**From:** [paul.marshall@hertfordshire.gov.uk](mailto:paul.marshall@hertfordshire.gov.uk)  
**To:** [Planning](#)  
**Subject:** Planning application 6/2019/1192/HOUSE - 34 Sherrardspark Road  
**Date:** 11 June 2019 09:53:27

**Response to Planning application from Hertfordshire County Council (T and CP GDP Order 2015)**

**District ref:** 6/2019/1192/HOUSE

Erection of single-storey rear, part two-storey rear and a single storey side extensions, installation of window, formation of vehicle hardstanding and crossover, following demolition of attached double garage and utility room.

Drawing Title
Ground Floor Plan
as Proposed

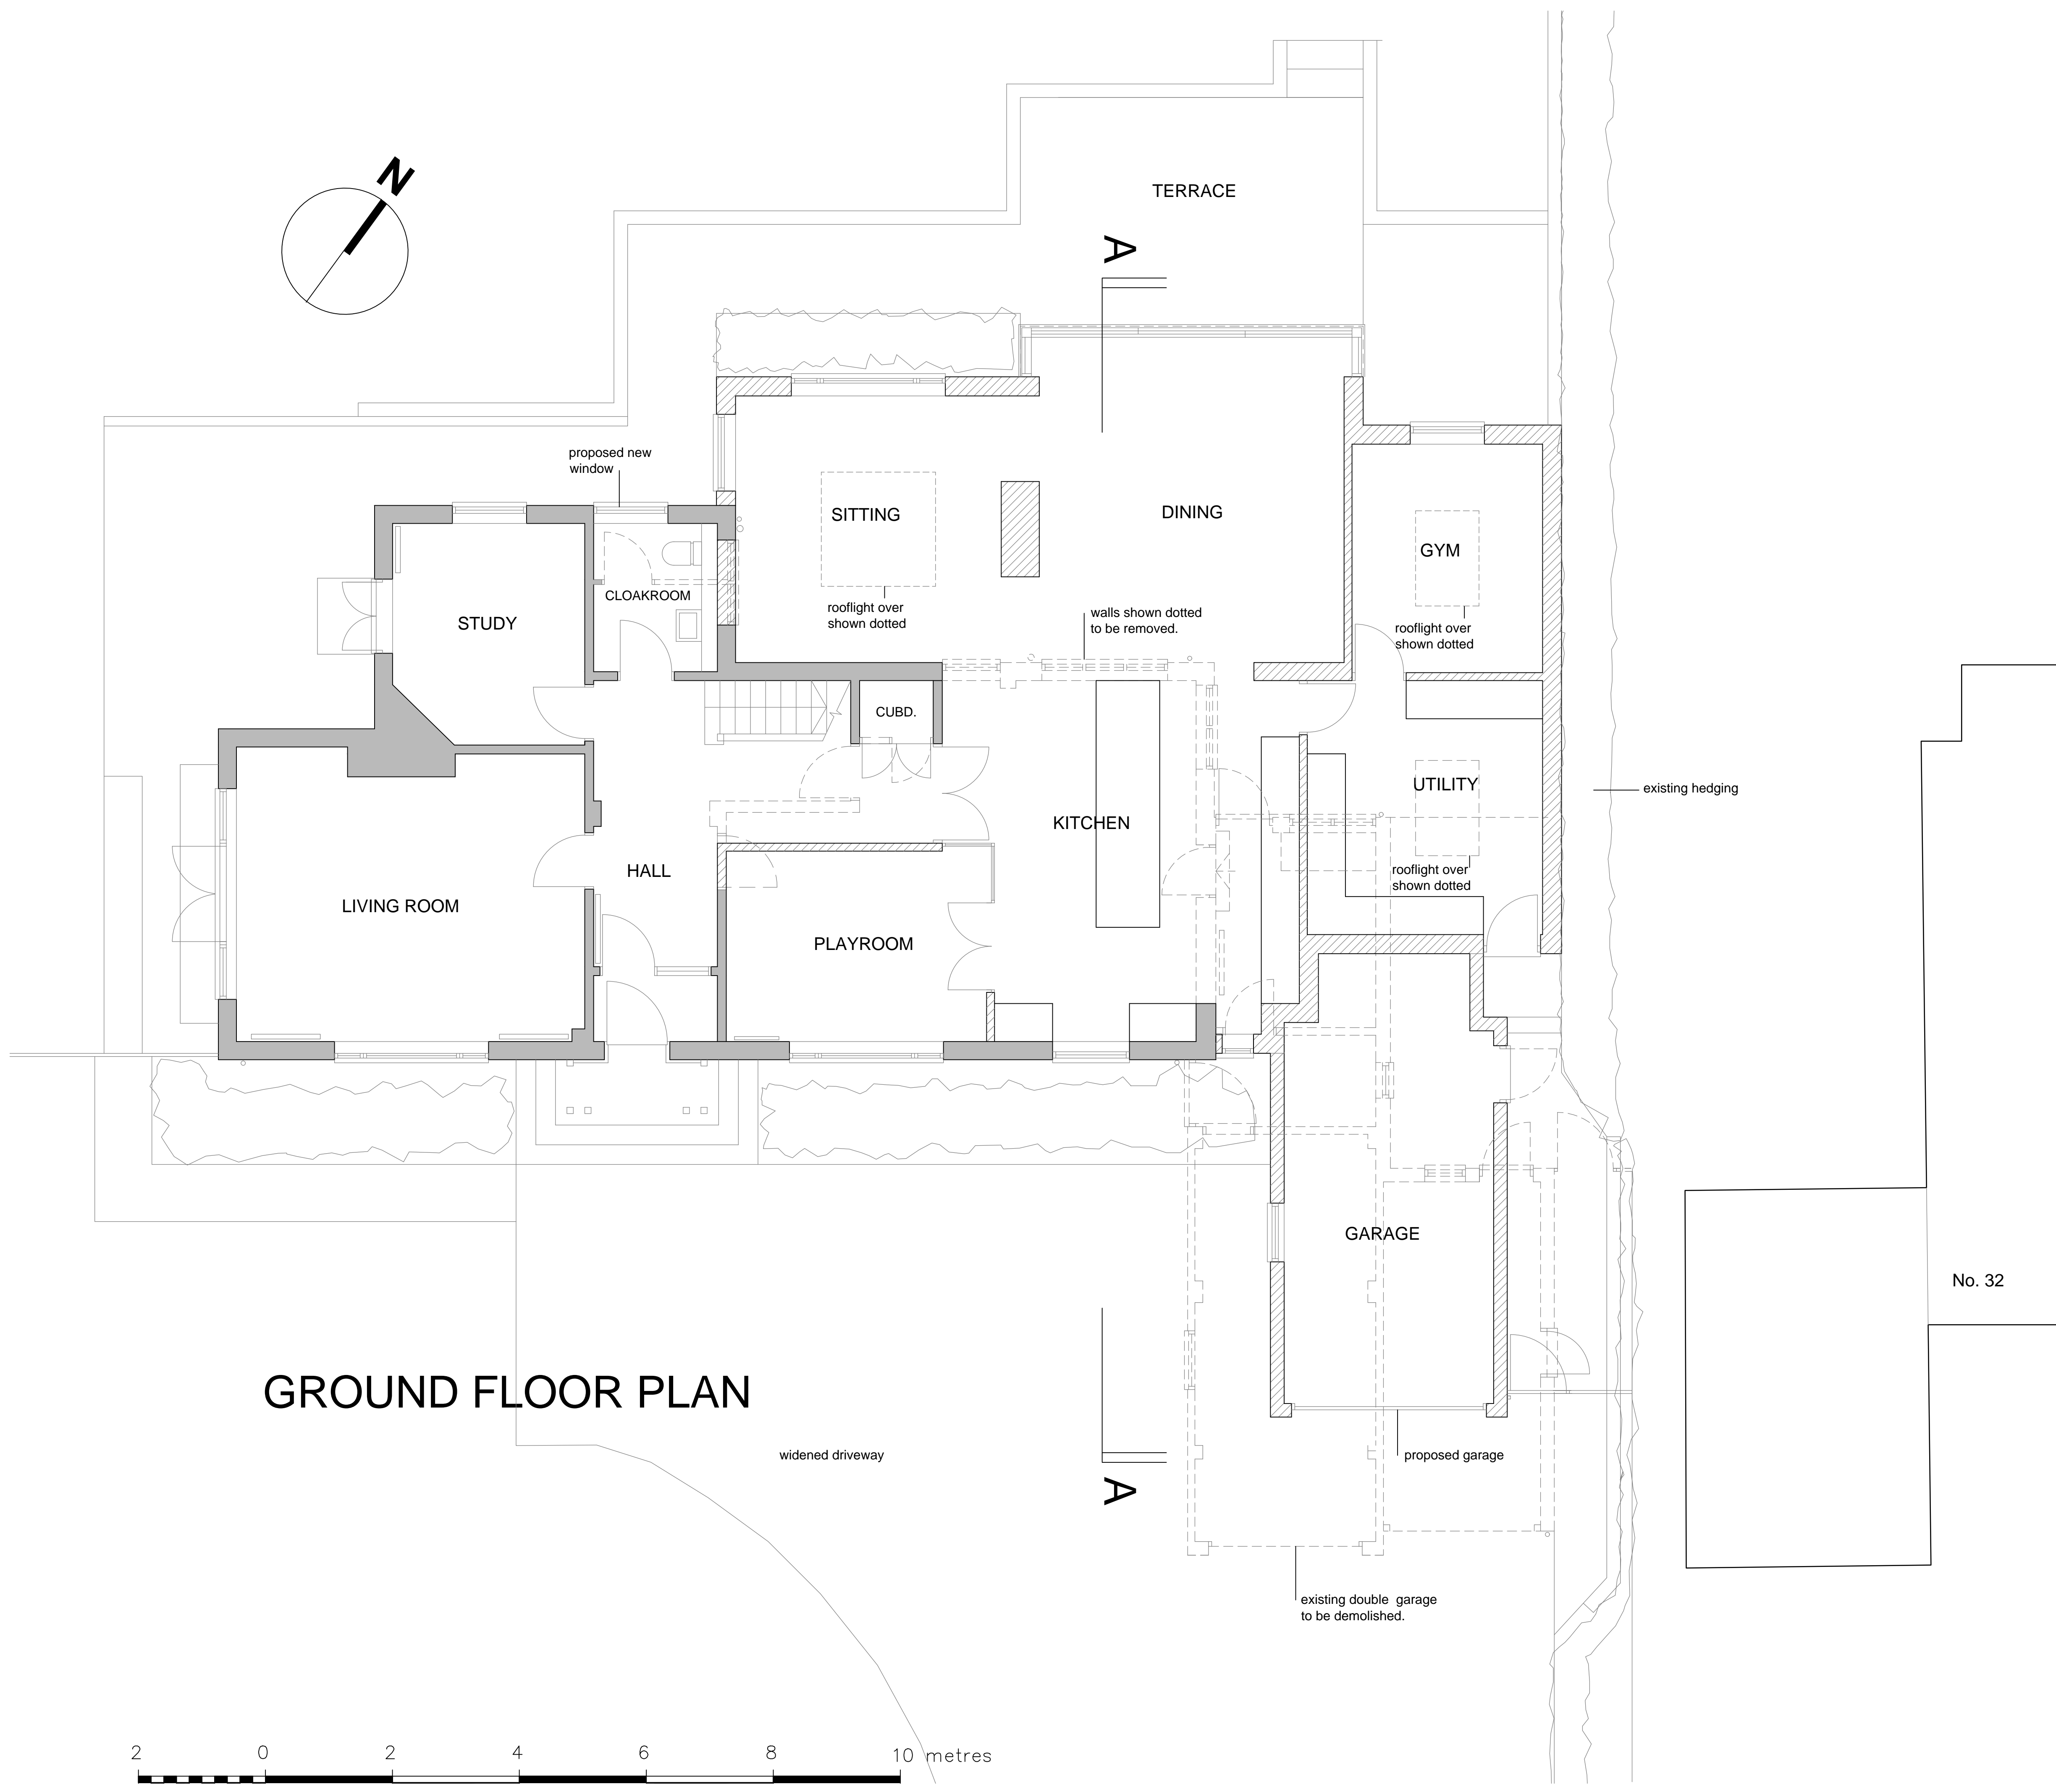
There is insufficient information supplied with this application to enable the Highway Authority to reach a recommendation. The plans do not provide the level of detail needed. Please see below for a guide to required information. a. Detailed Vehicle Crossover drawing to scale. b. Measurements of the Driveway c. Visibility splays. d. Depth of parking area Please find also Hertfordshire County Council's Dropped Kerbs (Residential Crossovers) Guidance. <https://www.hertfordshire.gov.uk/droppedkerbs/> In view of the above the highway authority recommends that the planning application is to be refused on inadequate information to support the proposal.
